North Central Area Committee Meeting

SHD0019/22

**North West Corner of Omni Park Shopping Centre,
Santry Hall Industrial Estate, Swords Road, Santry,
Dublin 9.**

Presentation conducted by Rebecca Greene, Executive Planner, on planning application SHD0019/22 (ABP-314458-22) for the construction of 457 Apartments, Crèche and associated works.

01 NORTH ELEVATION
P4001 SCALE 1:200 @A1

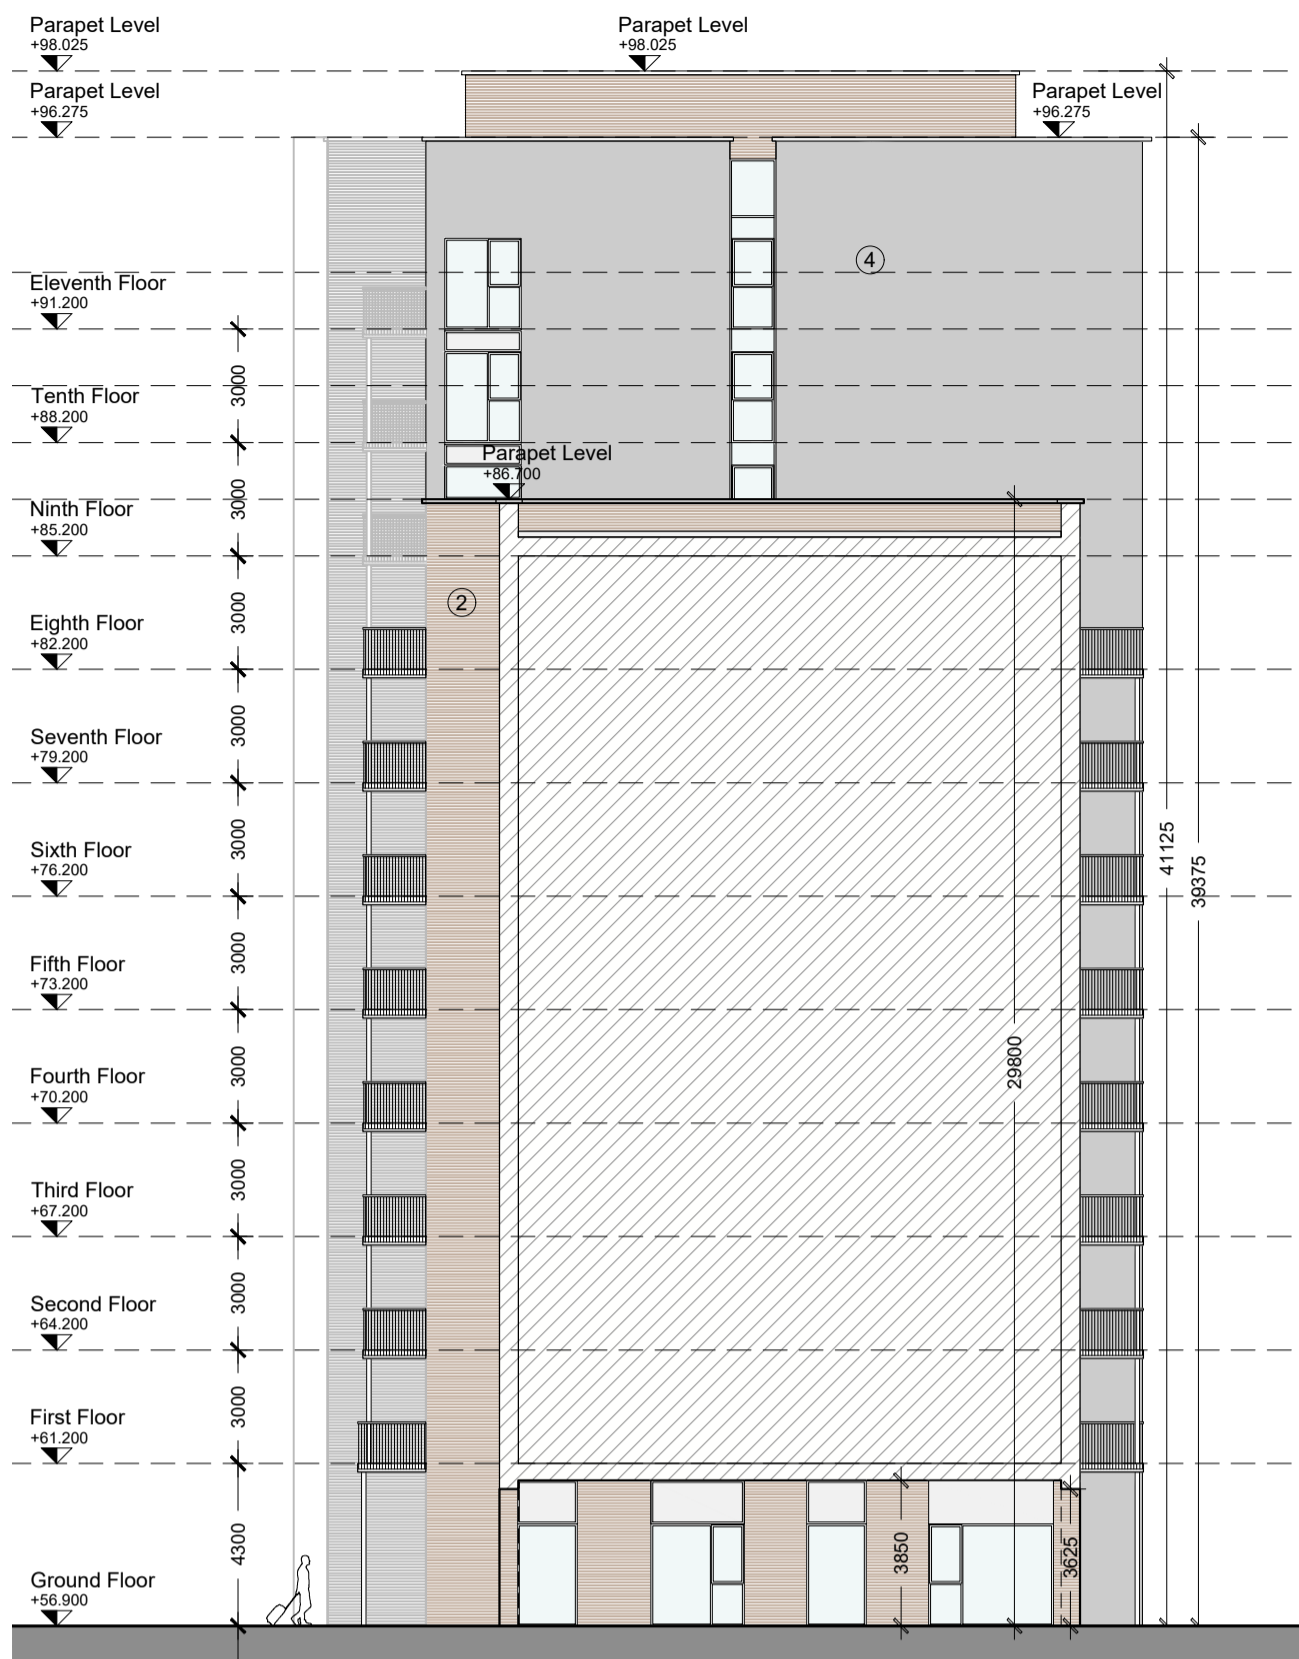
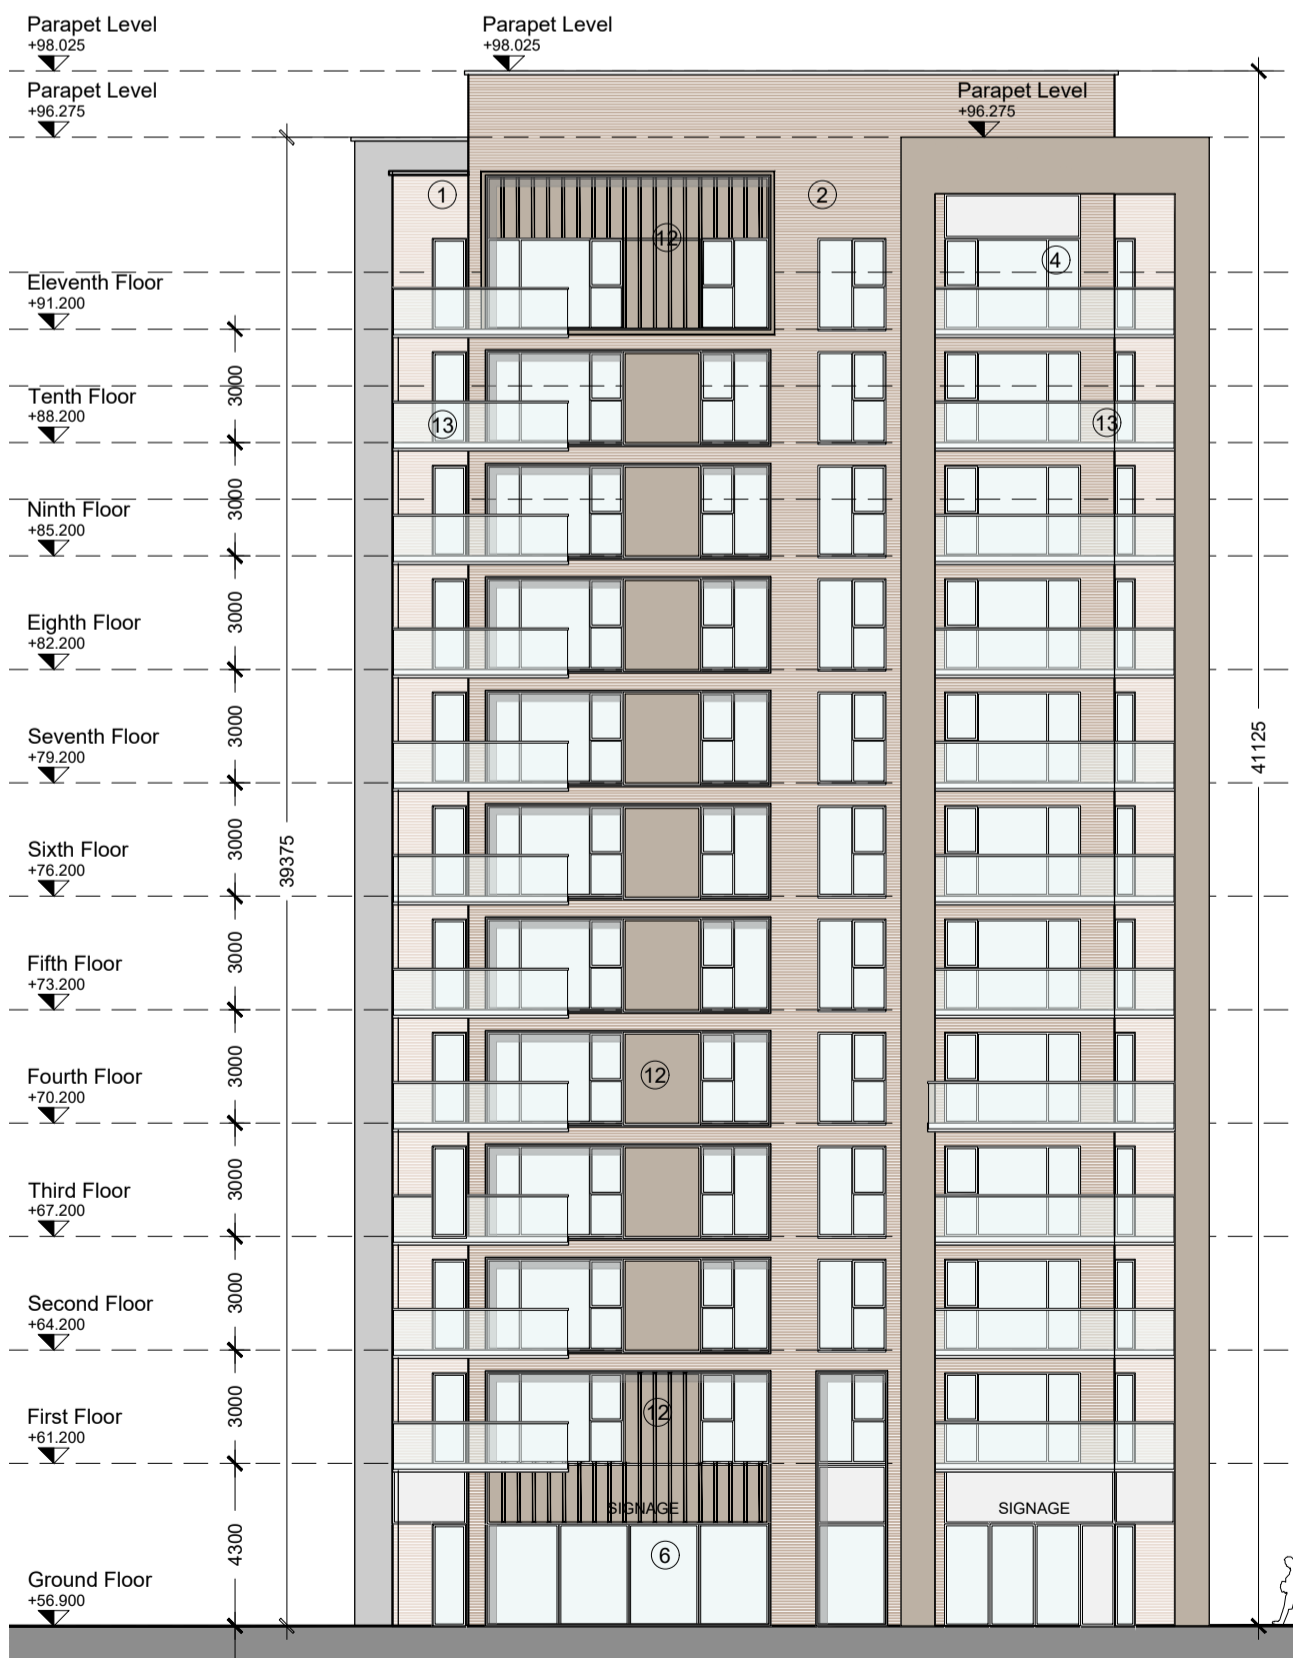
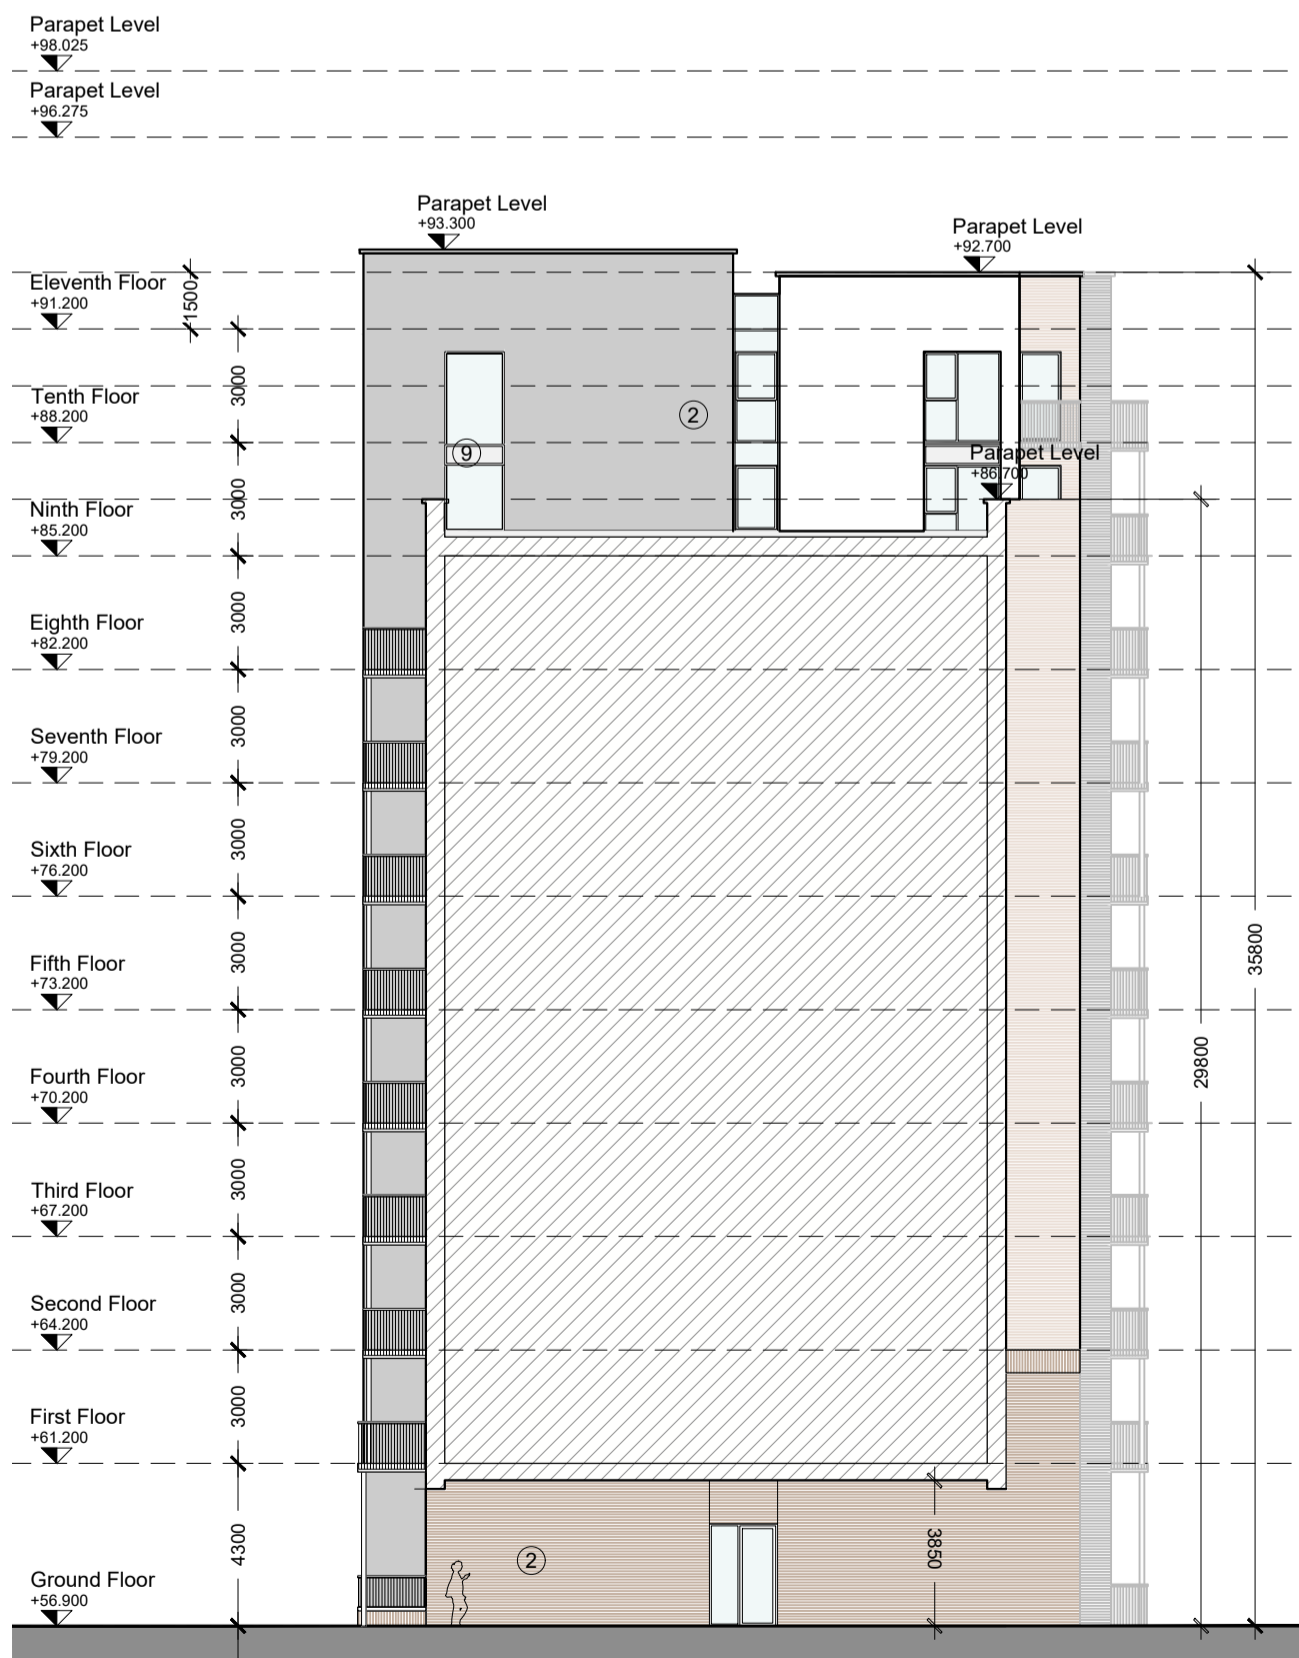
Clarity was also sought in relation to the actual heights in metres of the various blocks in the development and the distances in metres from the prospective development site to Shanliss Ave and concern was expressed of the visual impact on the skyline in a settled two storey residential area and reference made that this application should be declined on the basis of a material contravention
